Rezoning Transportation Analysis

Petition Number: Insert Zoning Petition #2021-047

Date	Description
04.29.2021	First Review (WB)

RZ-2

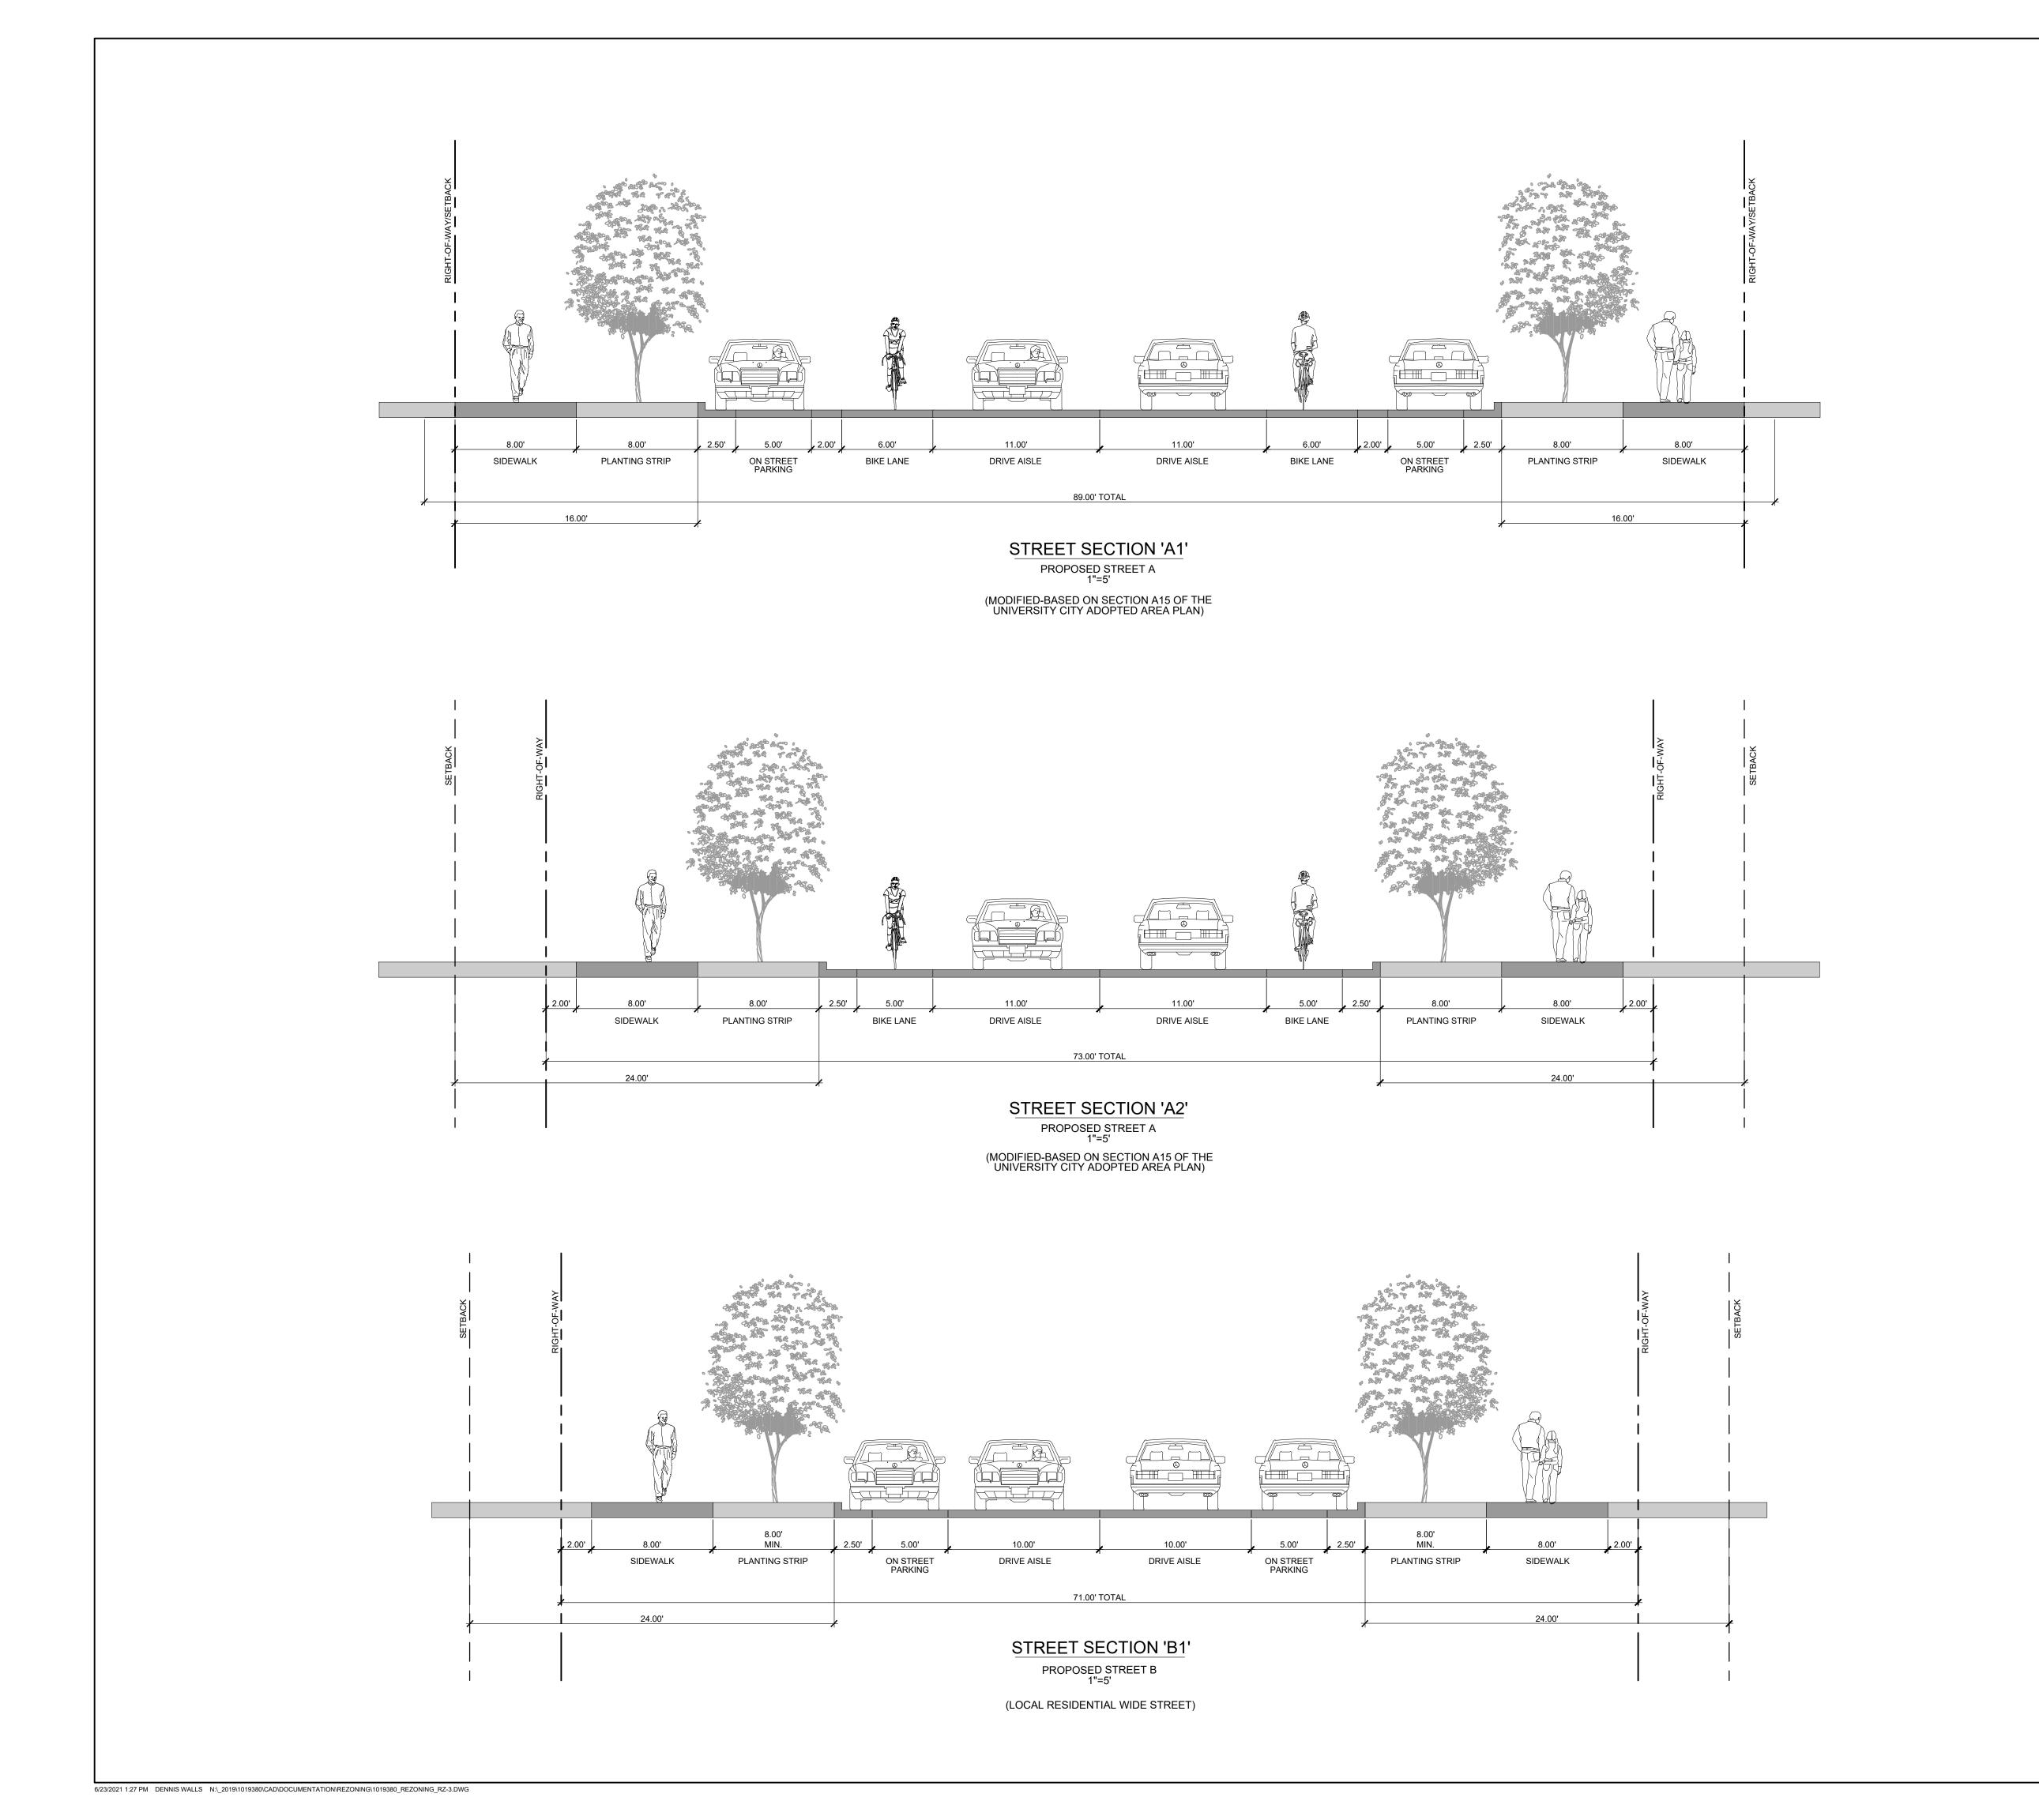
1. Traffic Study:
 A Traffic Impact Study (TIS) is not necessary for the complete review of this petition due to the site generating less than 2,500 daily trips. If during the permitting process the site generates more than 2,500 daily trips, then a traffic study will be required.
2. Please provide clarification on the two new site plan conditional notes listed under 3. Transportation Improvements and Access. I Proposed Improvements, c and d.
